# Adaptable Housing Report

Loftex

3-5 Help Street

**Project:** Project Name & Address  
**Document Type:** Adaptable Housing Report  
**Our Reference:** P222\_481-3 (AS4299) DV

Accessible Carpark - Highlighted ORANGE

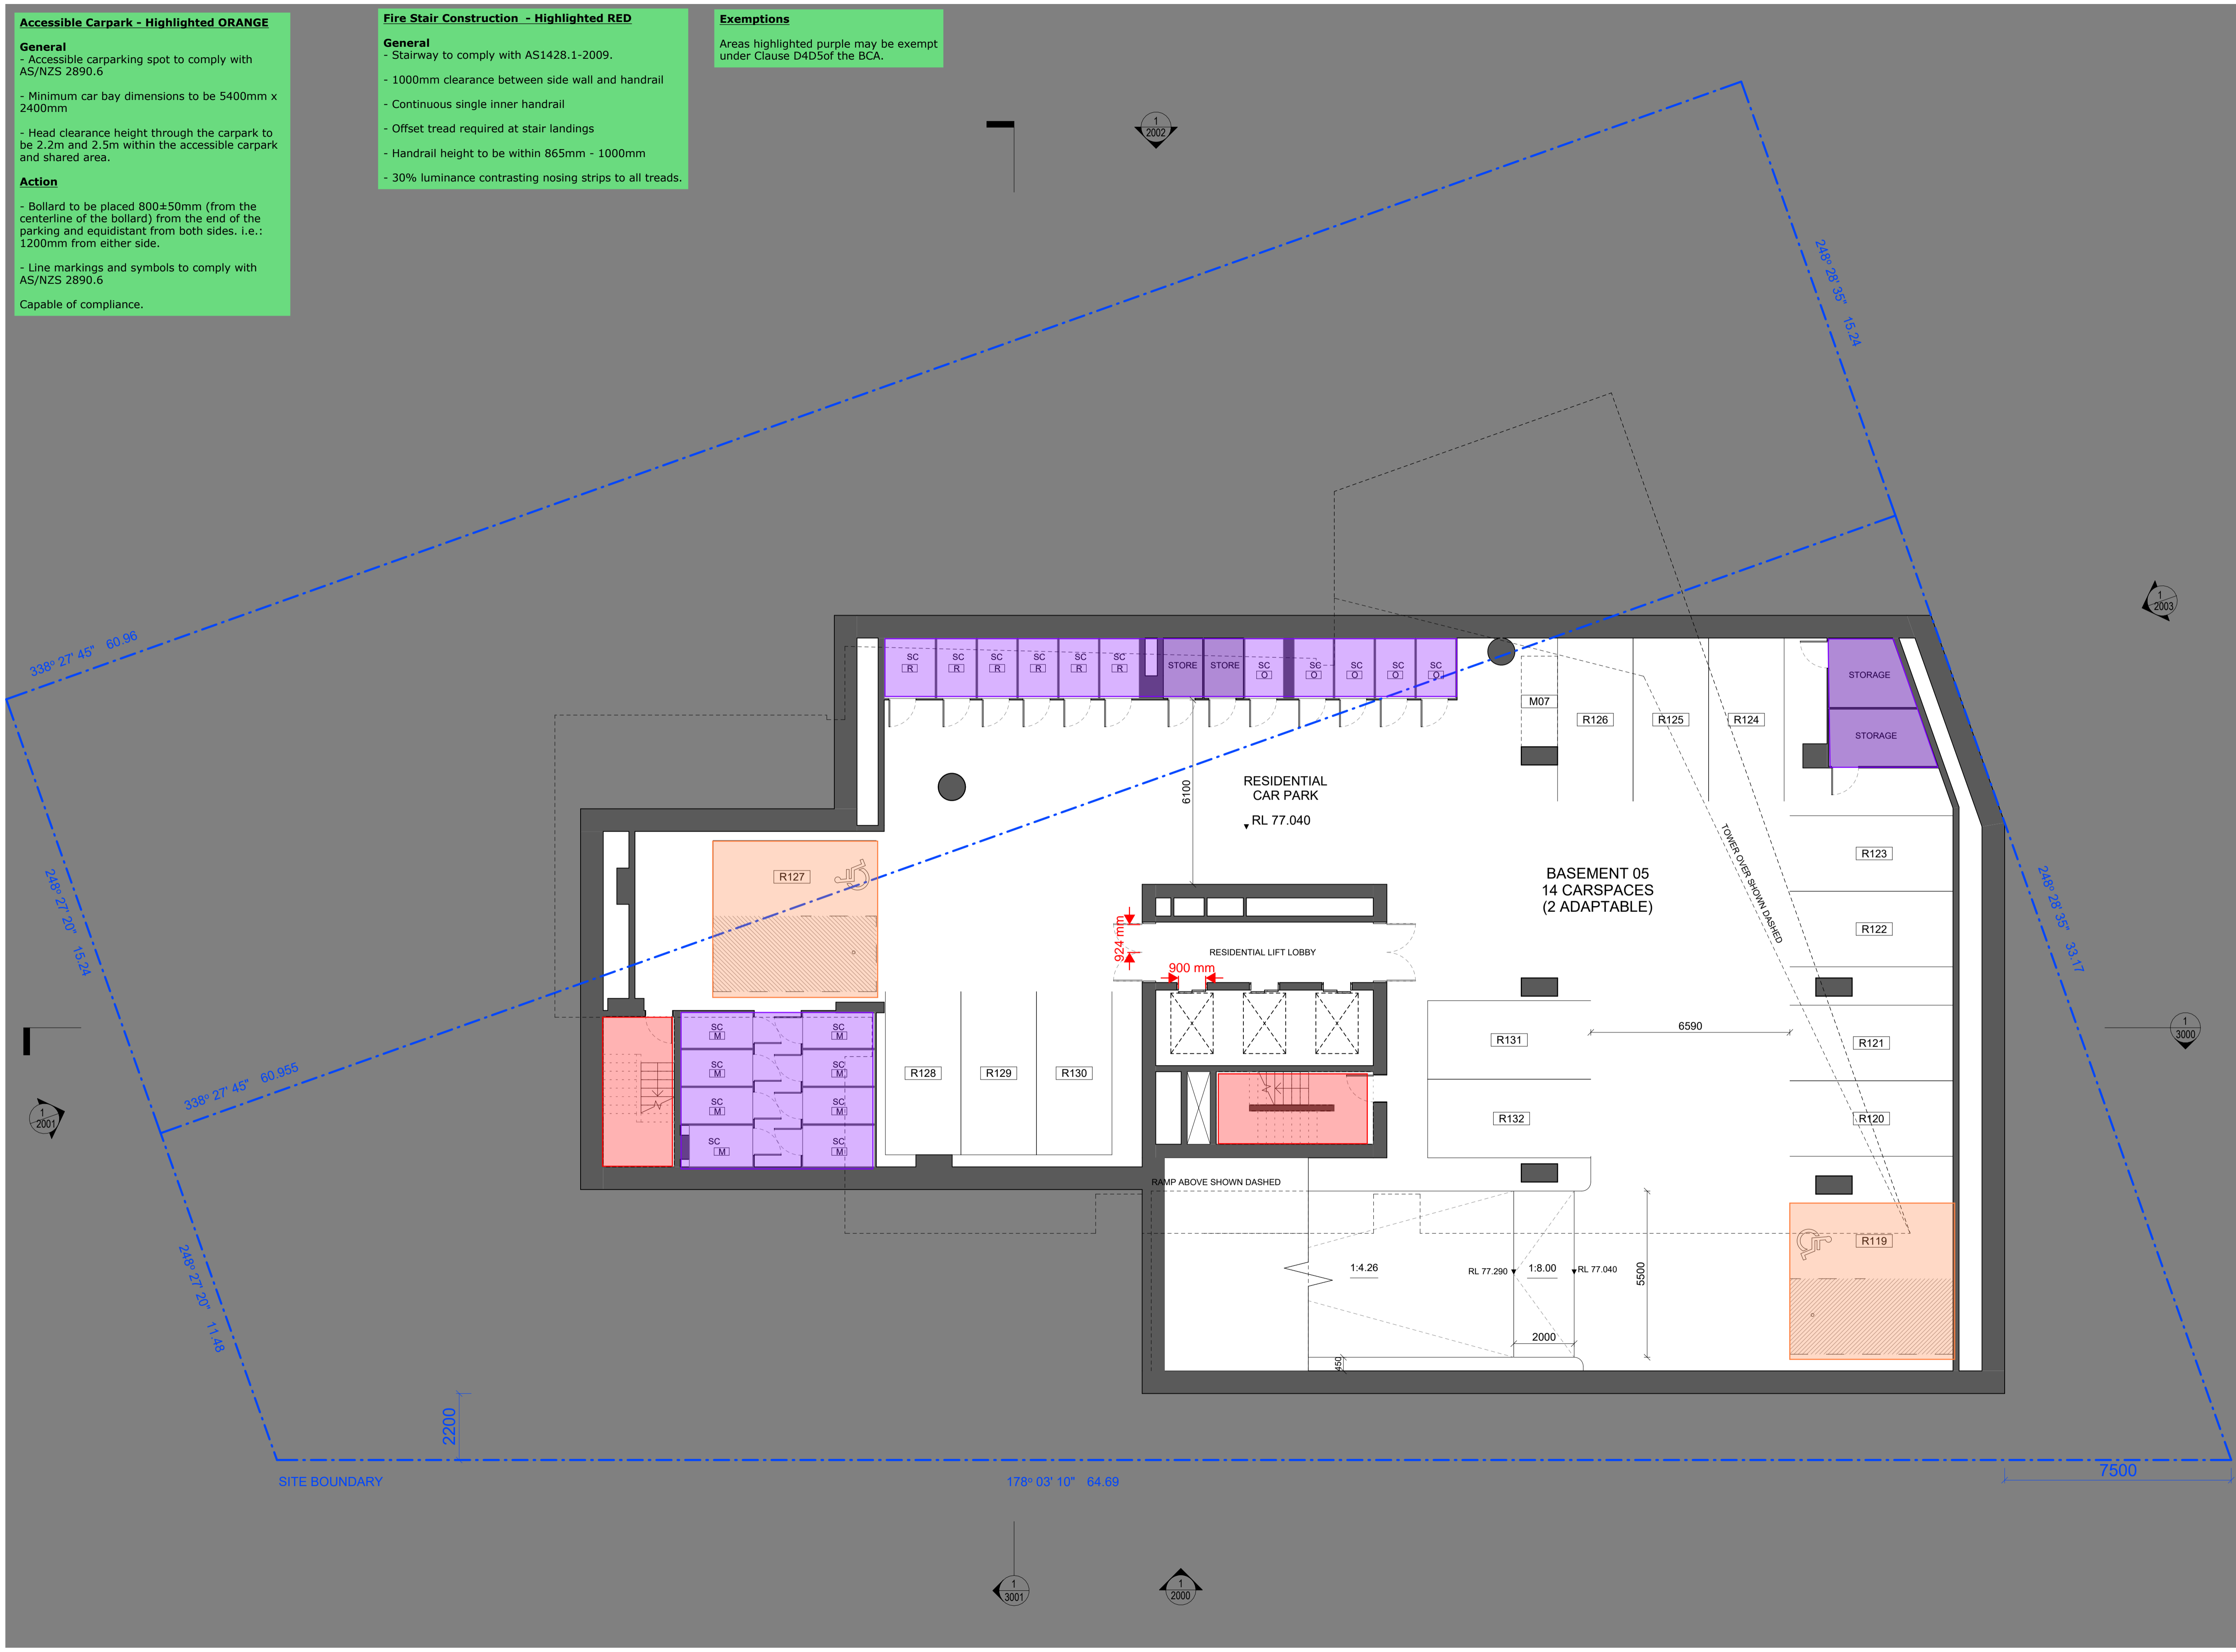
| ITEM                    | REQUIREMENT                                                                                                                                                                                                                                                           | ASSESSMENT                                                                                                           |
|-------------------------|-----------------------------------------------------------------------------------------------------------------------------------------------------------------------------------------------------------------------------------------------------------------------|----------------------------------------------------------------------------------------------------------------------|
| Symbol of Access        | The requirement for a symbol of access to be placed on the pavement shall not apply to any privately-owned parking space for people with disabilities associated with a single residence and intended primarily for use by occupants of that residence.               | <b>Capable of compliance</b><br>Please detail and show this design requirement in the architectural drawings.        |
| Finished Floor Gradient | Accessible parking spaces and shared areas shall at the same grade and the ground surface shall be not steeper than 1:40 (1:33 for external bitumen surfaces is acceptable).                                                                                          | <b>Further information required</b><br>Please detail and show this design requirement in the architectural drawings. |
| Head Height Clearances  | Vertical clearance leading to the accessible parking spaces shall be not less than 2200mm.                                                                                                                                                                            | <b>Further information required</b><br>Please detail and show this design requirement in the architectural drawings. |
| Head Height Clearances  | Vertical clearance at the accessible parking spaces and associated shared areas shall be not less than 2500mm.<br><br><i>Note: reduced headroom may be permitted in accordance with Figure 2.7 of AS/NZS2890.6:2009.</i>                                              | <b>Further information required</b><br>Please detail and show this design requirement in the architectural drawings. |
